15 December 2010

Re: Jones Bay Wharf Marina Development Pyrmont, Jones Bay Wharf, Pyrmont (MP09_0205)

Figure 3 - View 01 from cliff above Pirrama Road (proposed)

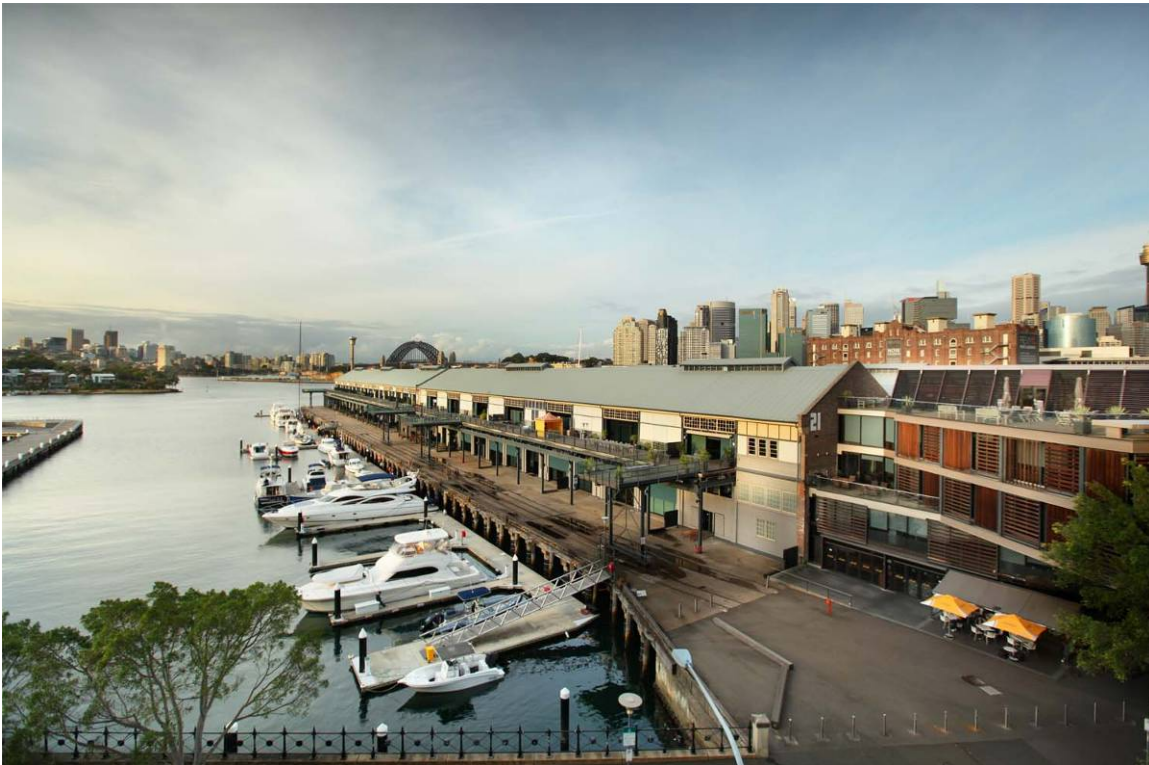
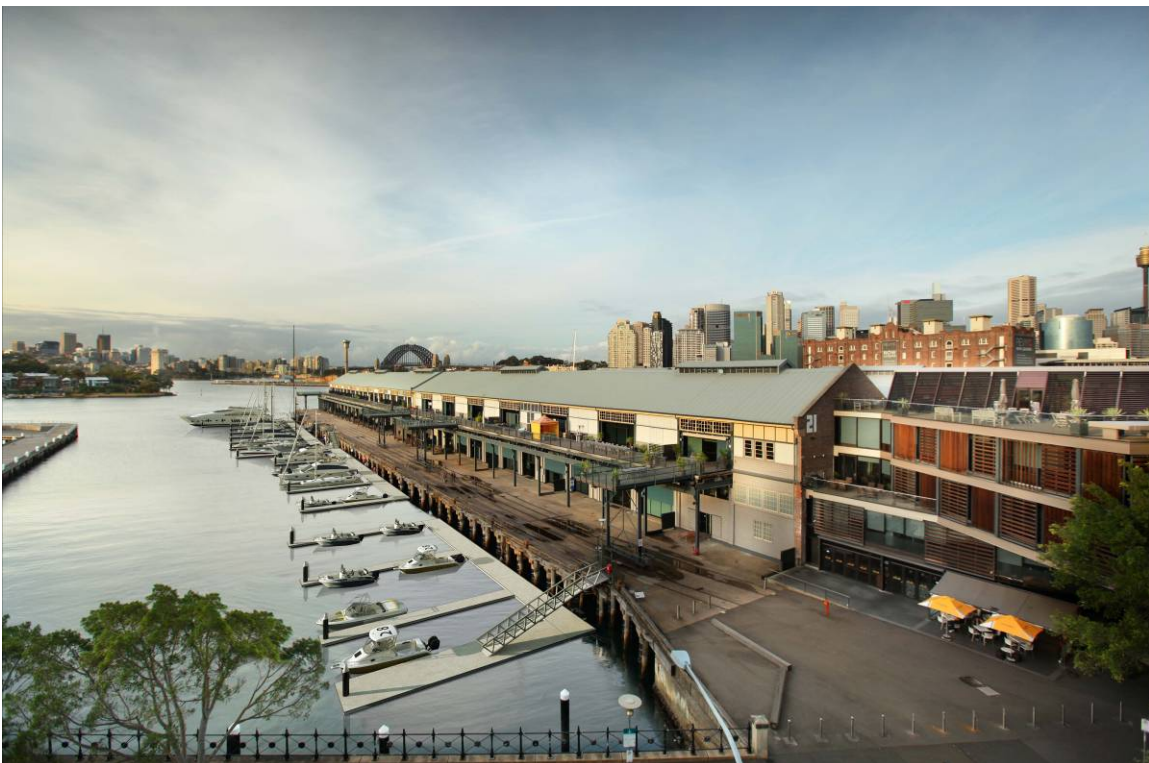
- The impact of the vessels heights and scale on the loss of views from suites and the local area has not been addressed and misrepresented in Toga Development No. 27 Pty Ltd supplied photomontages.
